Access Report

University of Sydney ETP Stage 1
Alterations & Additions to an existing University building

Development Application Design Phase

Date - 30 November 2017
For - Laing O'Rourke Australia Construction Pty Ltd
Ref - 17380 – R1.1

Access Strategy - Level 02

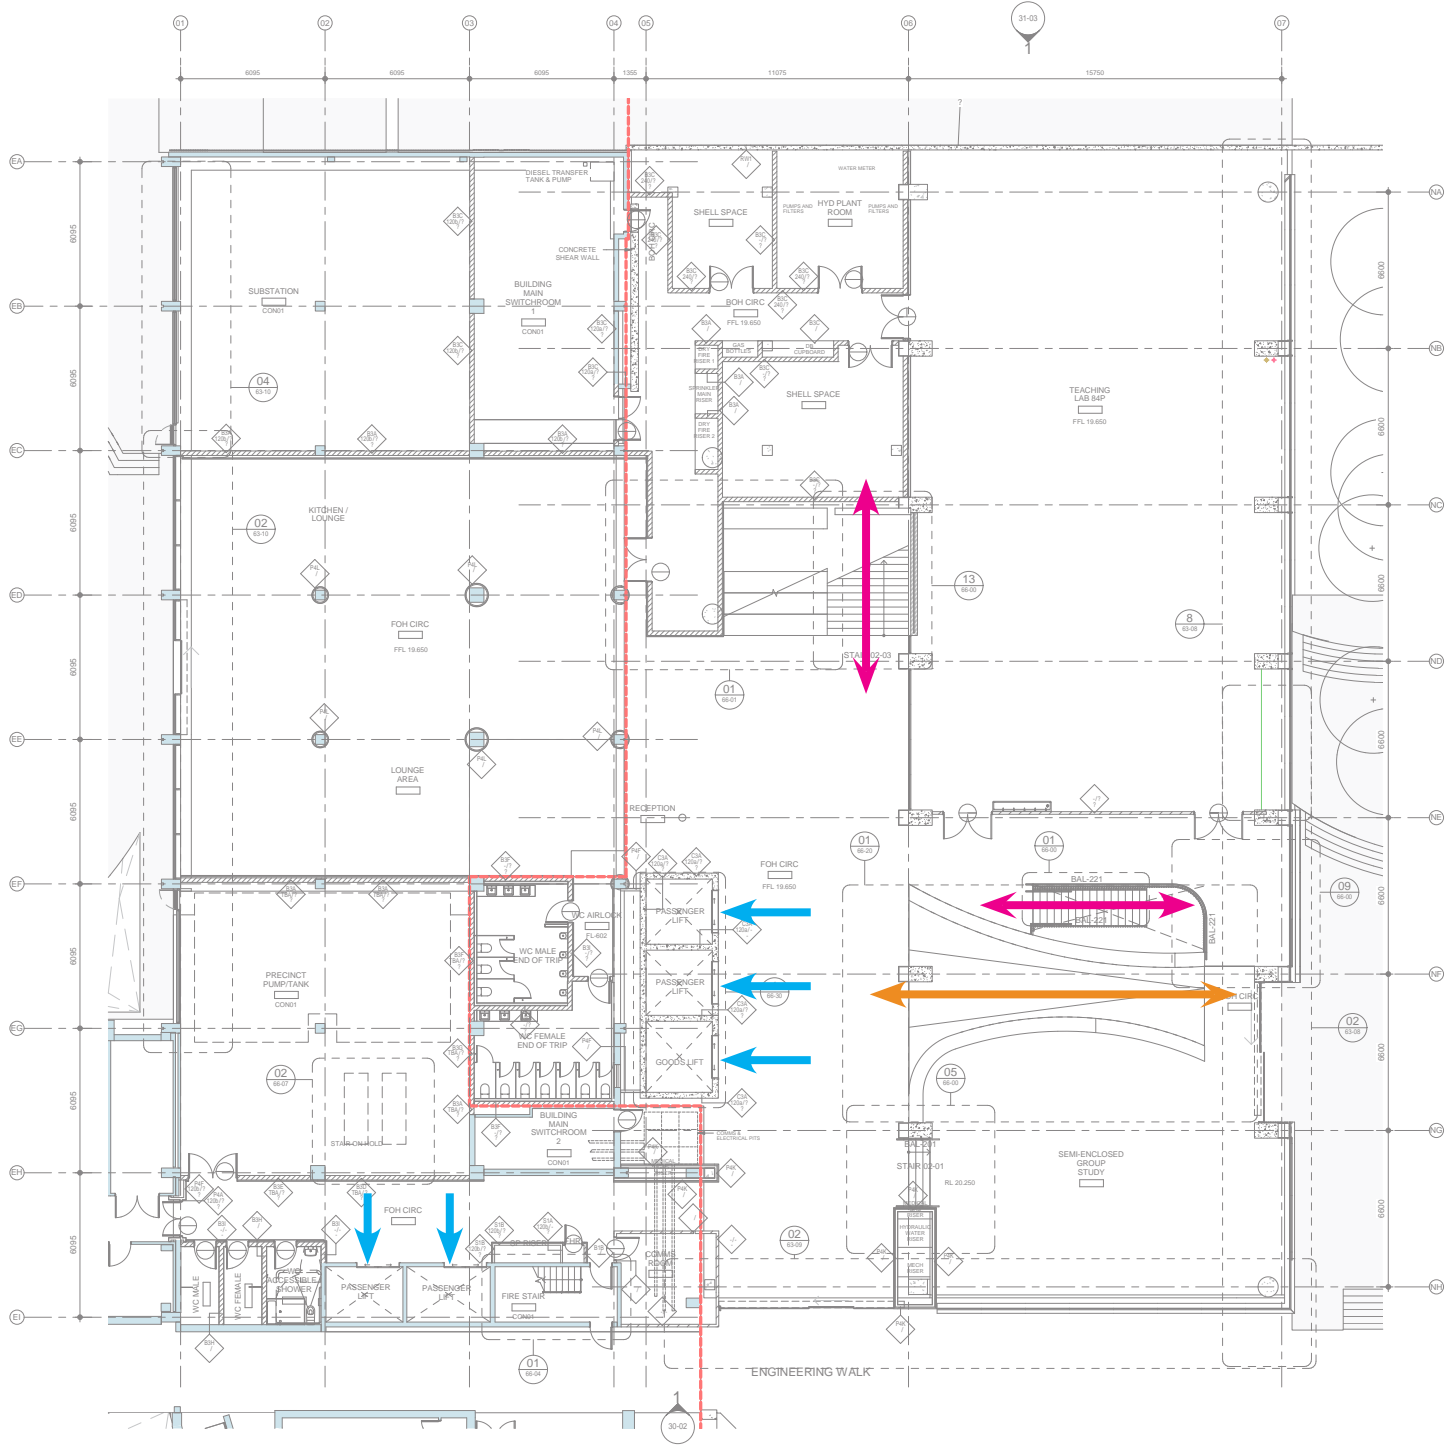
The Accessible sanitary facility at Level 2 is not located within the same bank as the general toilets and causes a DTS compliance departure with this clause.

Resolution is readily at CC design phase by either –

- a. Relocating the toilet(s); or
- b. We can produce a *BCA Performance Solution* to demonstrate the suitability of the current design. Enhanced way-finding signage will be required.
